<b>Application Ref:</b>	3/2020/1084	 <div>Ribble Valley Borough Council</div> <div><a href="http://www.ribblevalley.gov.uk">www.ribblevalley.gov.uk</a></div>	
<b>Date Inspected:</b>	6/1/2021		
<b>Officer:</b>	BT		
<b>DELEGATED ITEM FILE REPORT:</b>		<b>Decision</b>	Approval

<b>Development Description:</b>	Proposed two storey side extension and single storey rear extension.
<b>Site Address/Location:</b>	16 Wellbrow Drive, Longridge. PR3 3TB.

Drawing Title <b>Proposed Site Plan</b>		
Scale <b>1:100 @ A3</b>	Date <b>Dec 2020</b>	Drawn <b>BT</b>

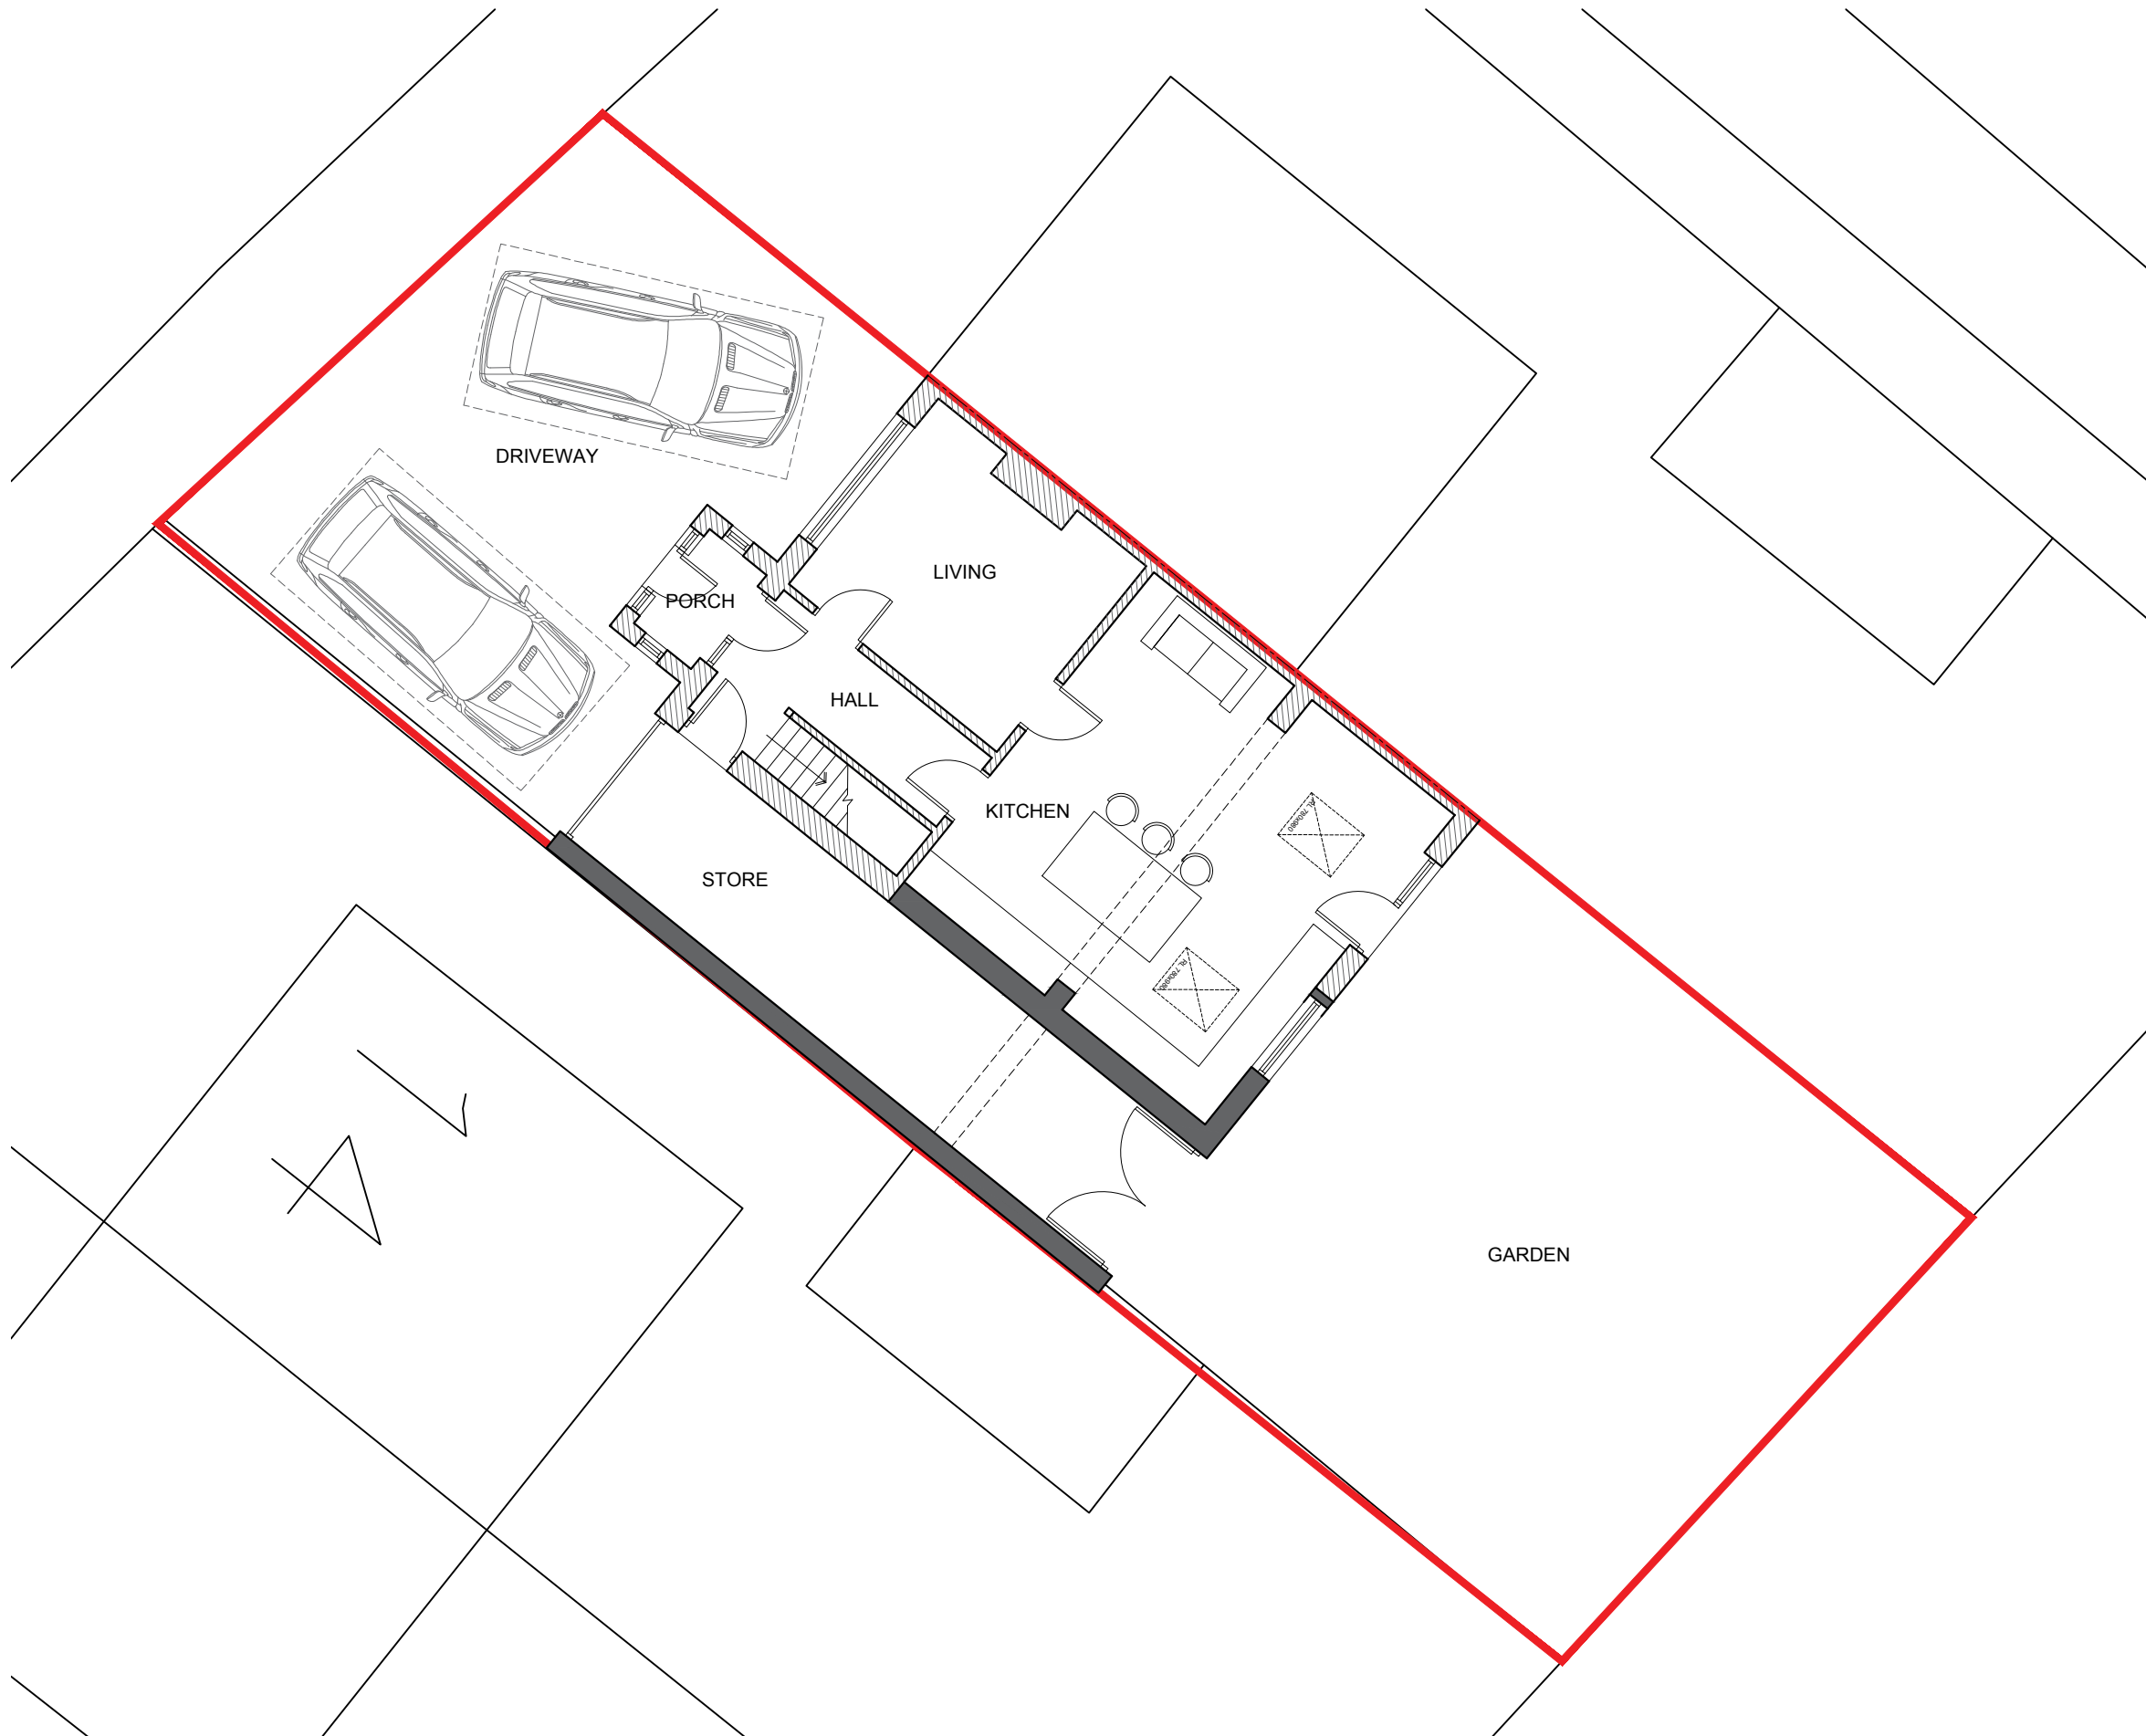
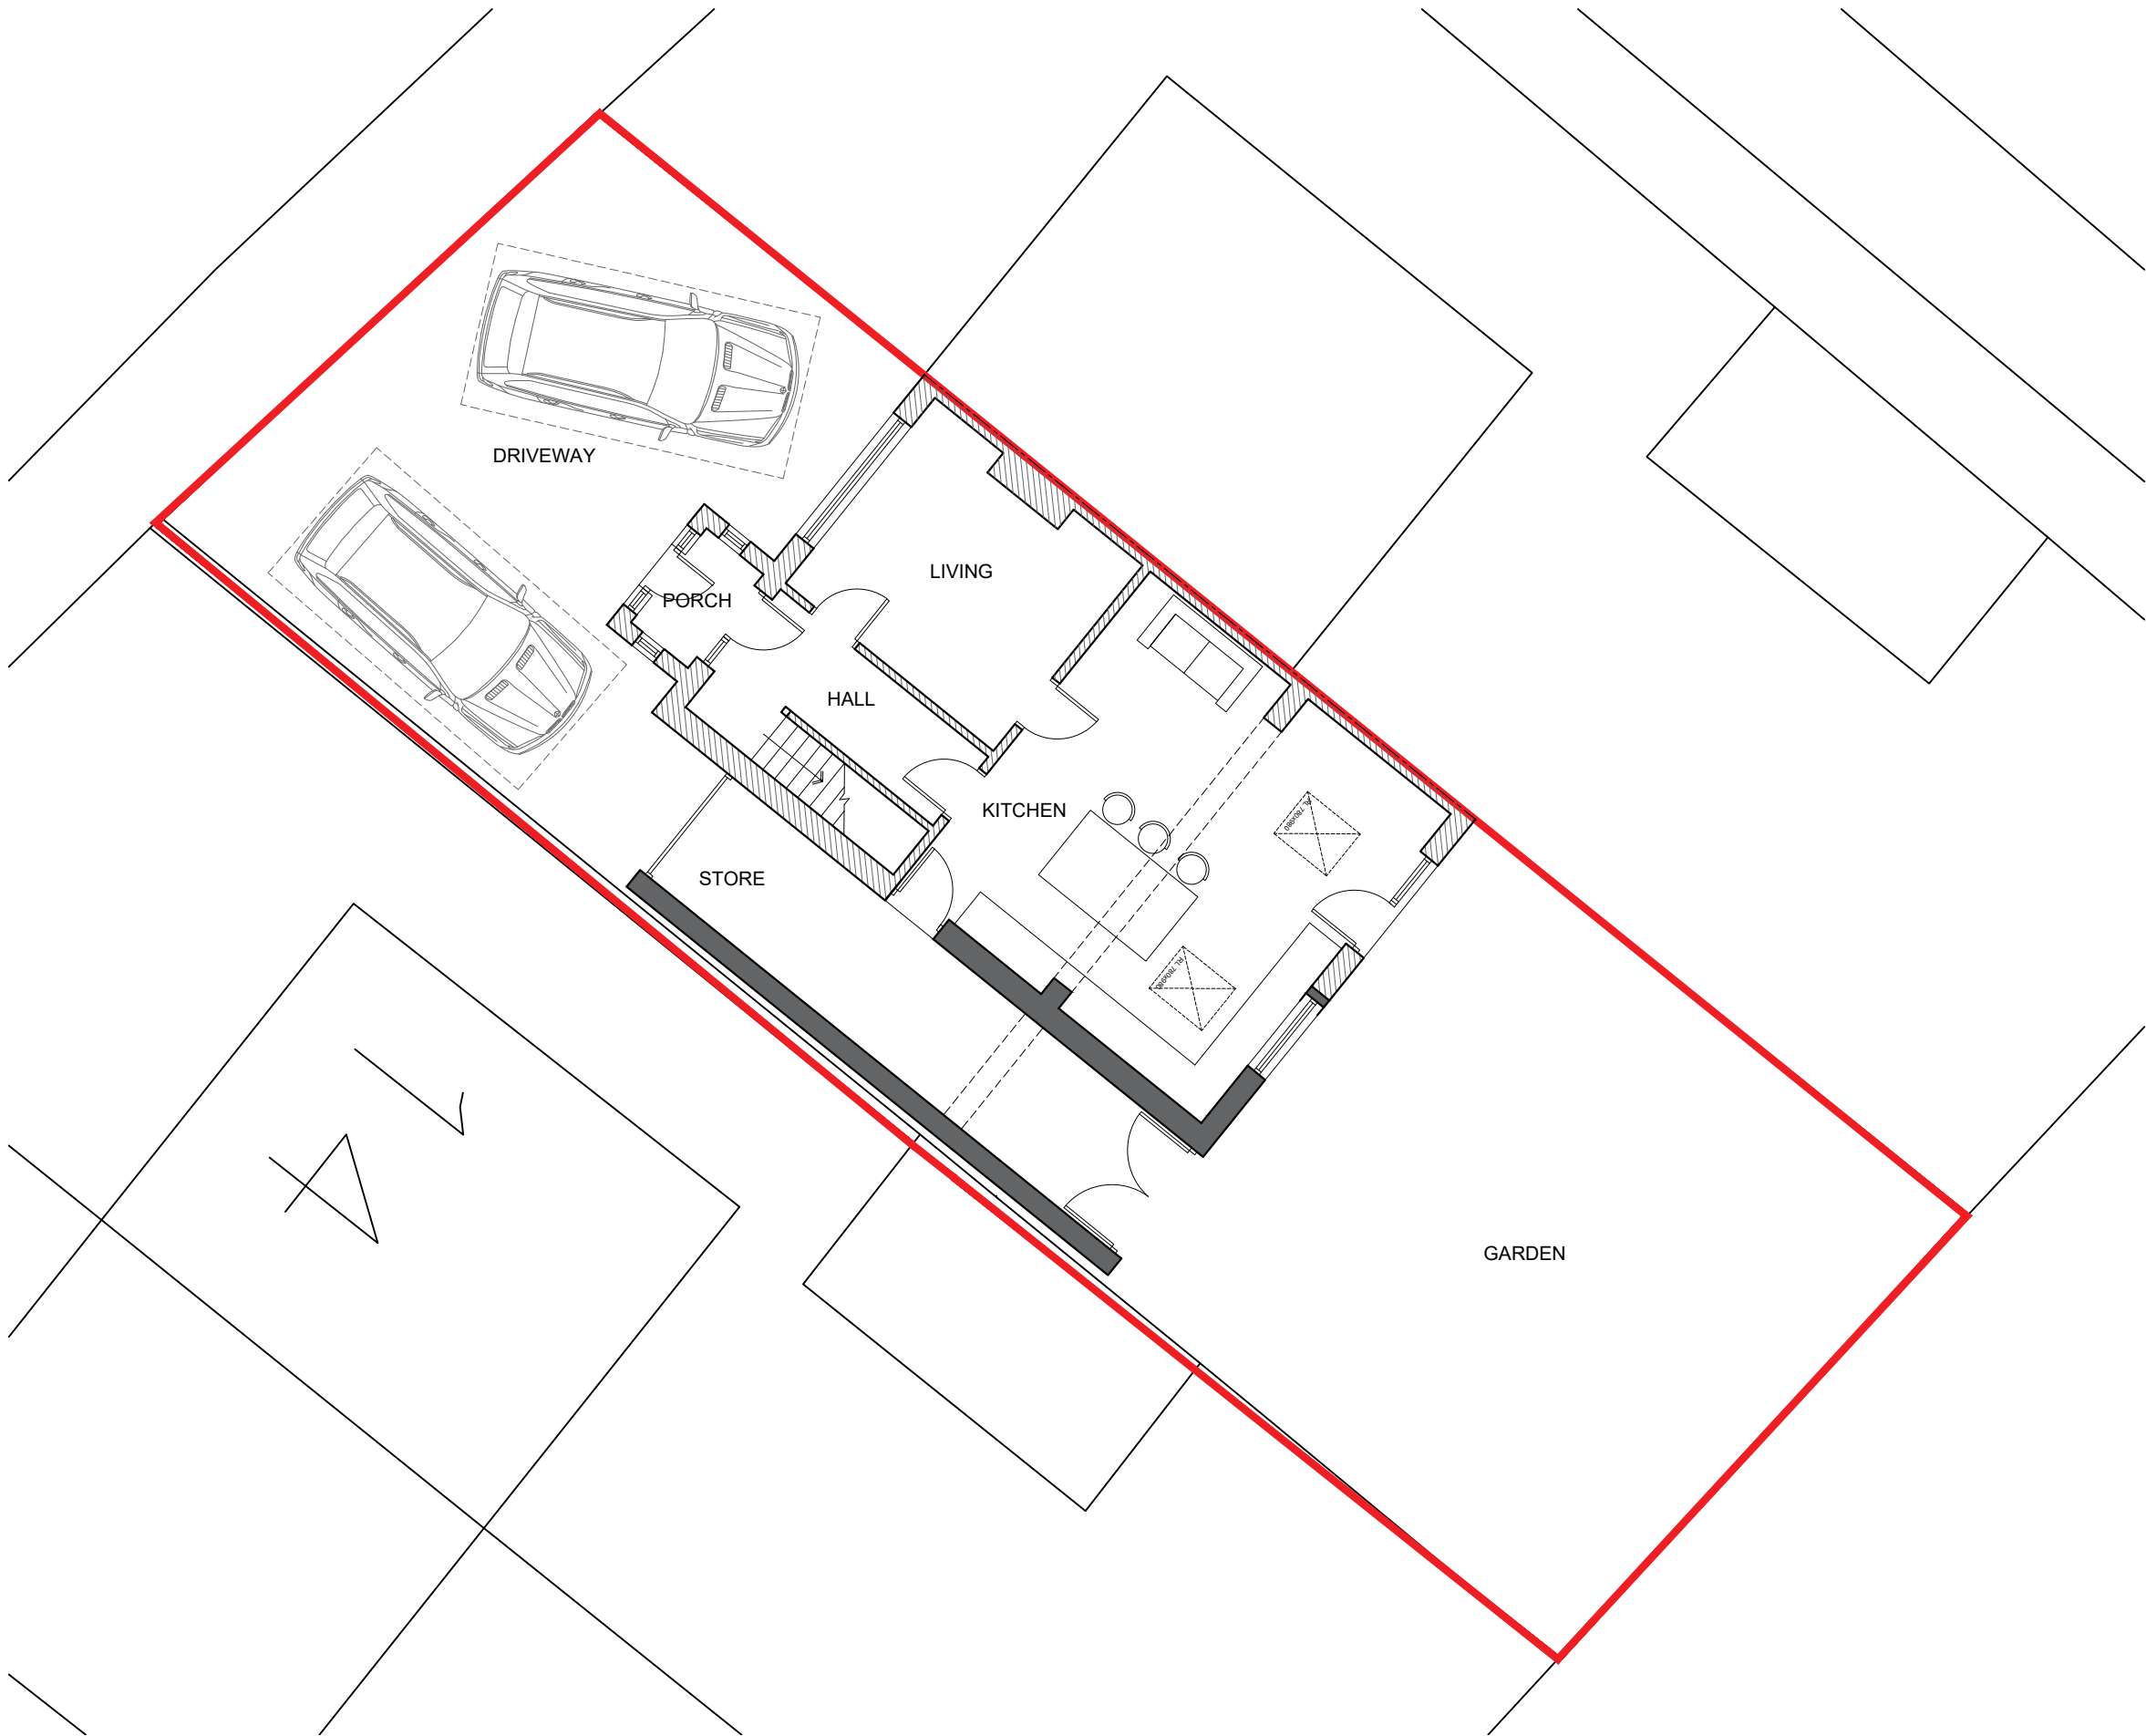
The original plans submitted for the proposal included a two-storey side extension with a widthways projection which comprised the entire space between the existing property and the boundary line with No. 14 Wellbrow Drive. The roof and eaves height of this extension were originally set to match the eaves and roof height of the main property at the first-floor level. The front elevation of the extension was originally set back 300mm from the front elevation of the main property at the first-floor level however the front elevation of the extension at the ground floor level was set in line with the main property.

As such, it was considered that the original proposal would have had a detrimental impact on visual amenity which would have created a visual imbalance between the pairing of semi-detached dwellings at No. 16 and No.18 Wellbrow Drive by virtue of its continuous roof line, front elevation and excessive widthways projection. It was also considered that the proposed works could have led to a terracing effect if a similar proposal was ever implemented at the neighbouring property of No.14 Wellbrow Drive.

The applicant has since resubmitted an amended plan in which the widthways projection of the two-storey side extension has been reduced to 2.2 metres. Side extensions are generally considered to be acceptable when sited at a distance of at least 1 metre from any side boundary however the amendment proposed is acceptable in this case given the constraints of widthways space on the existing property. The front elevation of the two-storey side extension has also been set back 1.3 metres from the main property which in turn has significantly reduced the eaves and roof height of the side extension.

The two-storey side extension will be viewable from Wellbrow Drive and as such will have some visual impact on the existing street scene. However, the amended proposal will be set back from the main property with a reduced widthways projection and roof line, both of which will significantly reduce the previously identified unbalancing effects, terracing effects and overall impact upon visual amenity in the surrounding area.
